# Rezoning Transportation Analysis

Petition Number: 2020-013

Date	Description
02-24-20	First Review (EL)
08-19-20	Second Review (KP)
09-17-20	Third Review (KP)

Proposed Zoning	0.61 ac of UR-2 (CD)	Need clarification from petitioner	Site Plan: 12-23-19
Proposed Zoning	0.61 ac of UR-2 (CD)	Need clarification from petitioner	Site Plan: 7-10-20 (submitted on 8/17/2020)
Proposed Zoning	0.61 ac of UR-2 (CD)	Need clarification from petitioner	Site Plan: 7-14-20 (submitted on 9/14/2020)

RZ-1

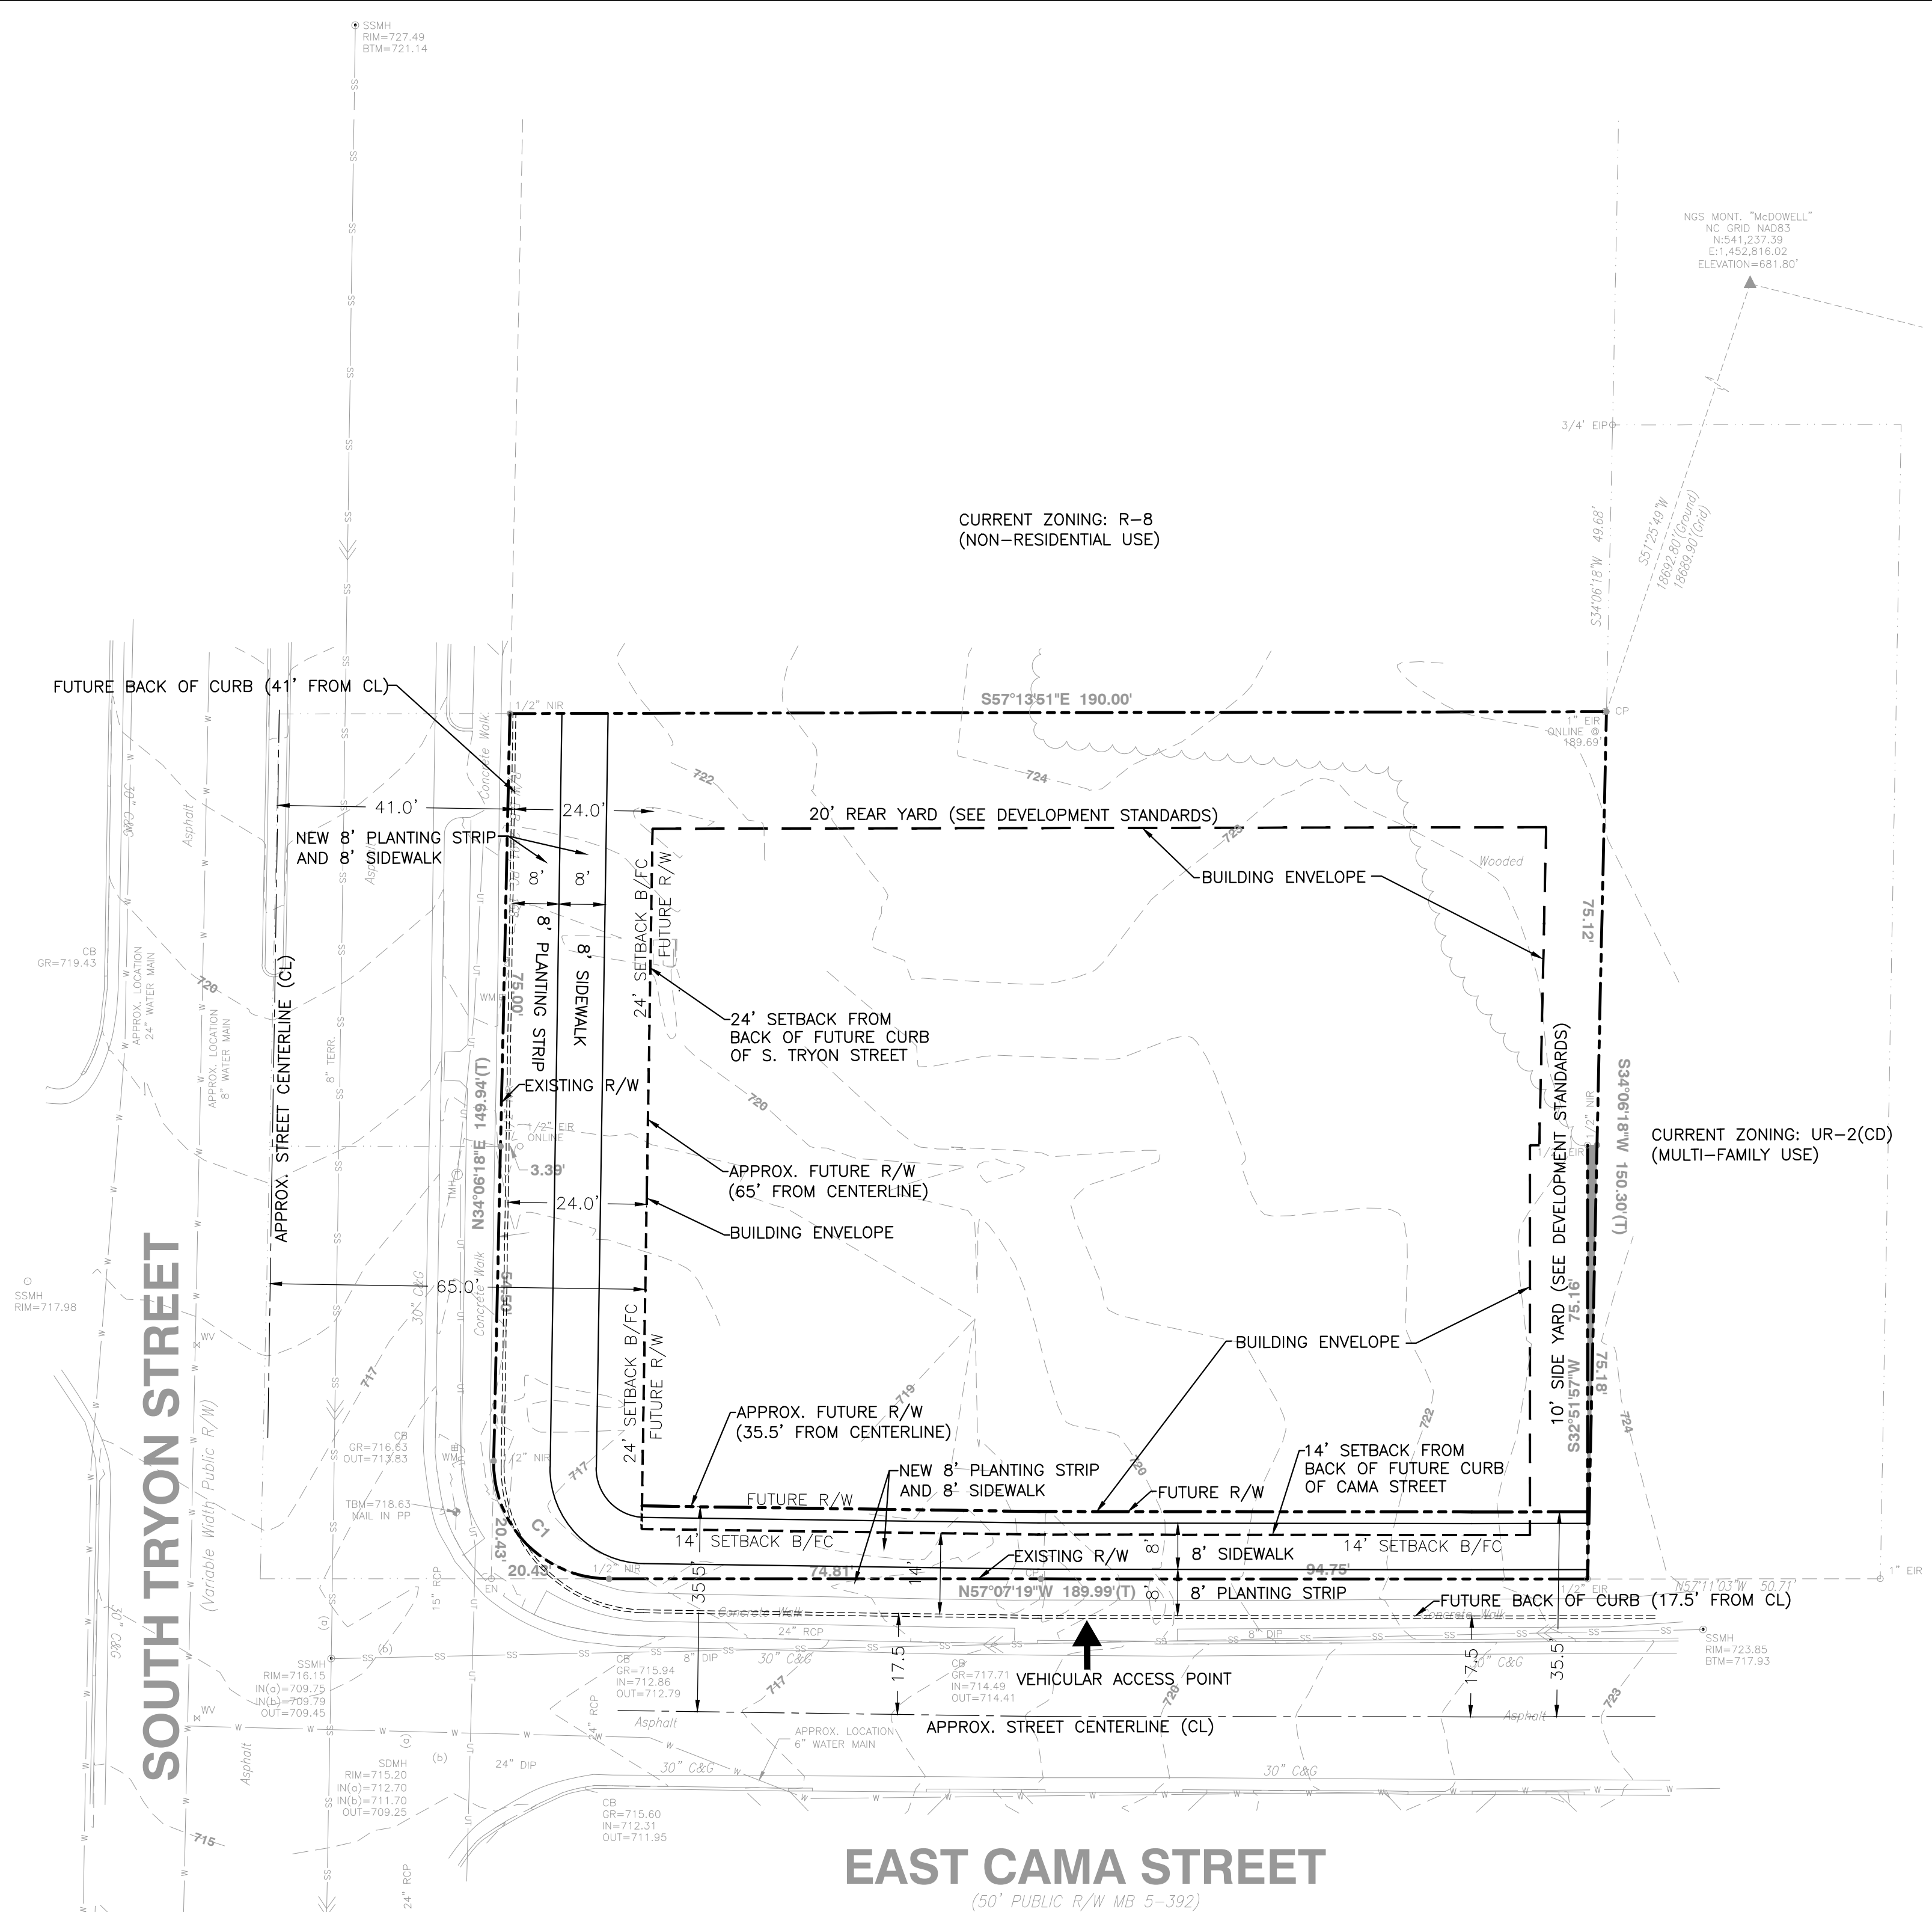
1. **Curbline** The proposed zoning district has a setback measured from back of the existing or proposed future curbline.
  - a. ~~**South Tryon Street:** The future location of curb and gutter is 41 feet from road centerline, per the council adopted CDOT Streets Map.~~
  - b. **East Cama Street:** The future location of curb and gutter is 21.5 feet from road centerline, per the council adopted CDOT Streets Map.

Label and dimension the curb and gutter from the centerline for each road.

3. Revise the site plan and conditional note(s) to show the East Cama Street future right-of-way that is proposed 35.5 feet from the road centerline and to dedicate 36.5 feet of right of way from centerline, per the CDOT Streets Map and the Charlotte Land Development Standards Manual (CLDSM), Standard Detail U-05-D – Commercial Wide Street Typical Section (TOD only). For clarification, the future curbline is that within the CDOT Streets Map, instead of the Scaleybark Transit Station Area Plan. Label and dimension the right-of-way from the road centerline.

4. Revise the site plan and conditional note(s) to show the South Tryon Street future right-of-way that is proposed 65 feet from road centerline to dedicate 57 feet of Right-of-Way from centerline, per the CDOT Streets Map. Label and dimension the right-of-way from the road centerline.

5. Revise the site plan and conditional note(s) to commit to construct an 8-foot planting strip and 8-foot sidewalk, per the Scaleybark Transit Station Area Plan, with respect to the future curbline, along both South Tryon Street and East Cama Street. The Scaleybark Transit Station Area Plan remains as the reference for the streetscape requirements for this proposed rezoning.

**Updated Comment:** Will need to update FBOC along Cama Street to approve this comment.
6. Revise the site plan and conditional note(s) to provide two curb ramps at the intersection of South Tryon Street & East Cama Street.

7. Revise the site plan and conditional note of Section (C.Transportation.1.) to provide one access off of East Cama Street, via a CLDSM standard detail 1025.E - Type II Modified Driveway. NCDOT will not permit access off South Tryon Street.

**Updated Comment:** Driveway type should be included in the site plan and conditional notes.
8. Revise the site plan to add a note specifying dedication and fee simple conveyance of all rights of way to the City before the site's first building certificate of occupancy is issued. CDOT requests right of way set at 2' behind back of sidewalk where feasible.

9. Revise the site plan to show/propose a location for trash receptacles/pick-up.
10. Revise the site plan to add a note specifying all transportation improvements will be approved and constructed before the site's first building certificate of occupancy is issued. The petitioner may phase transportation improvements if said improvements and phasing are explicitly described in site plan notes.
